Subject: LU/320/18/T - 1 Watersmead Drive, Littlehampton

I write to you as I am currently writing your application for 1 Watersmead Drive, Littlehampton – LU/320/18/T.

Google Maps 3 Watersmead Dr

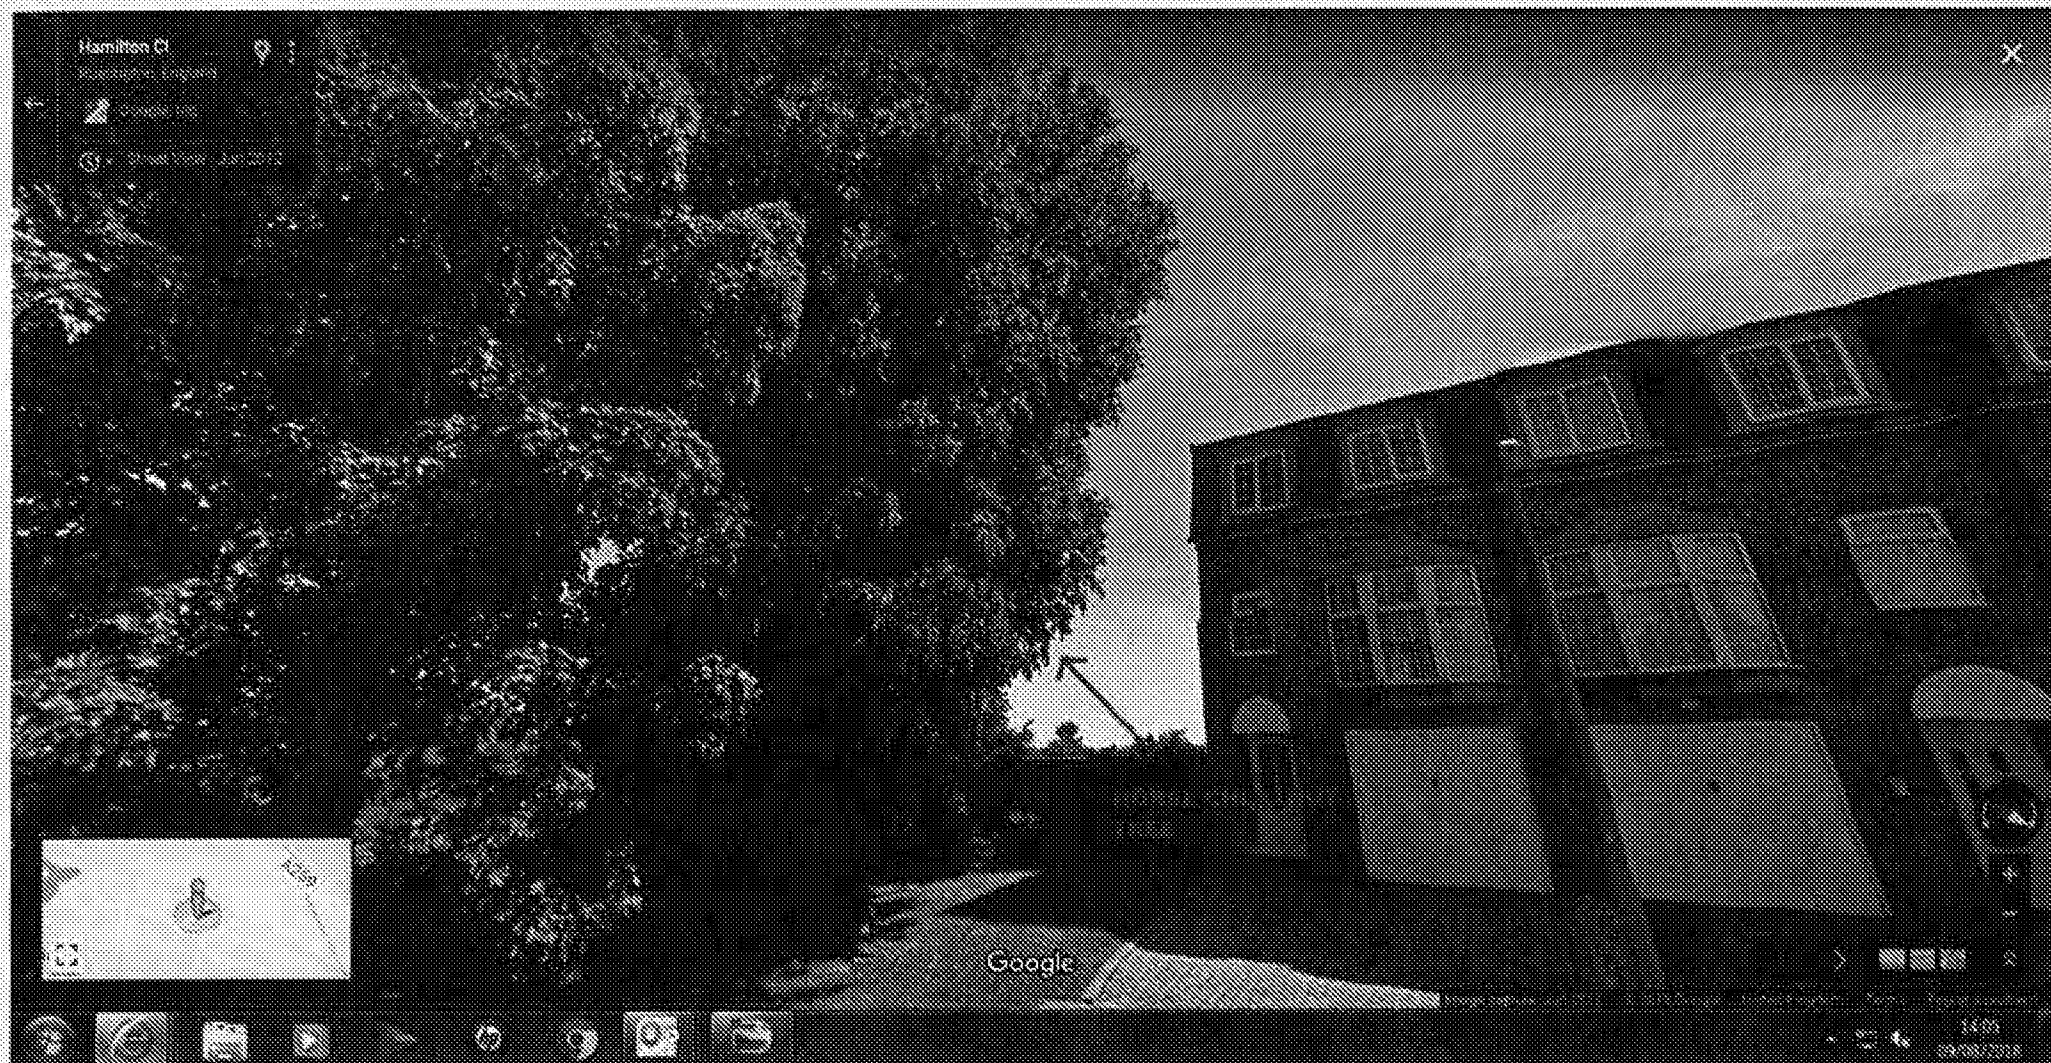
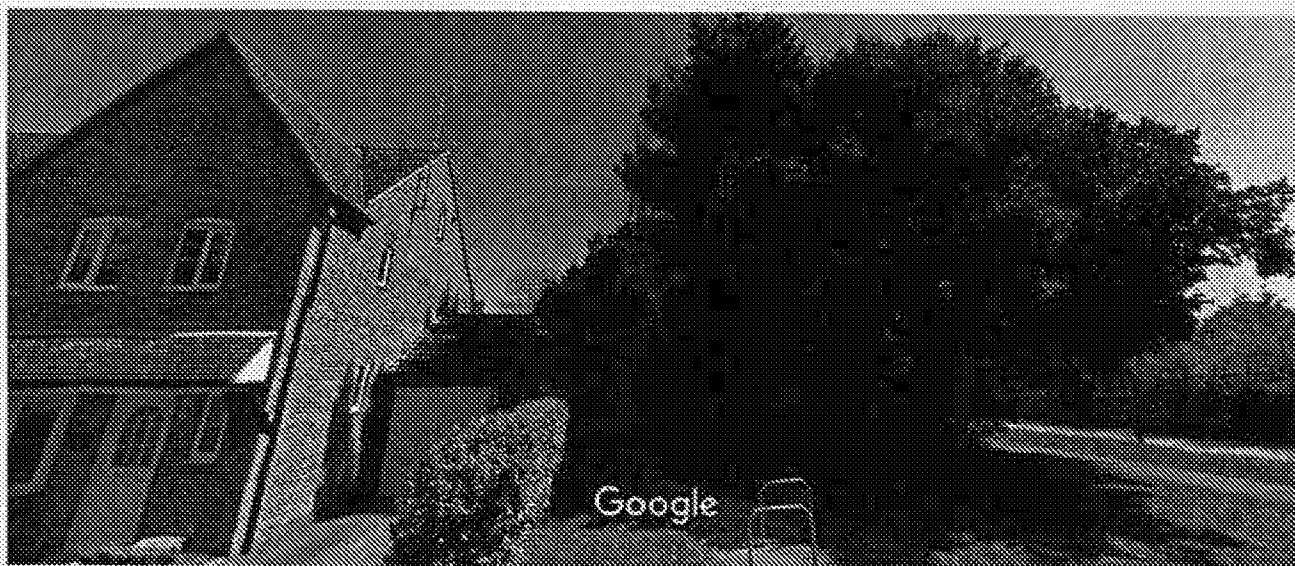
Having looked at the response from our Tree Officer he is recommending refusal of the proposed works to the Pine tree, however he has provided advisory comments.

- I would like to see the applicant re-submit with a revised work specification for T1 such as detailed below, which should address the concerns of the adjacent household without detriment to the tree's landscape and public amenity value.

1x Monterey pine

- Reduce prominent North tending lateral limb by no more than 2m in length, to just beyond last reduction point and at junction with an obvious strong lateral branch.
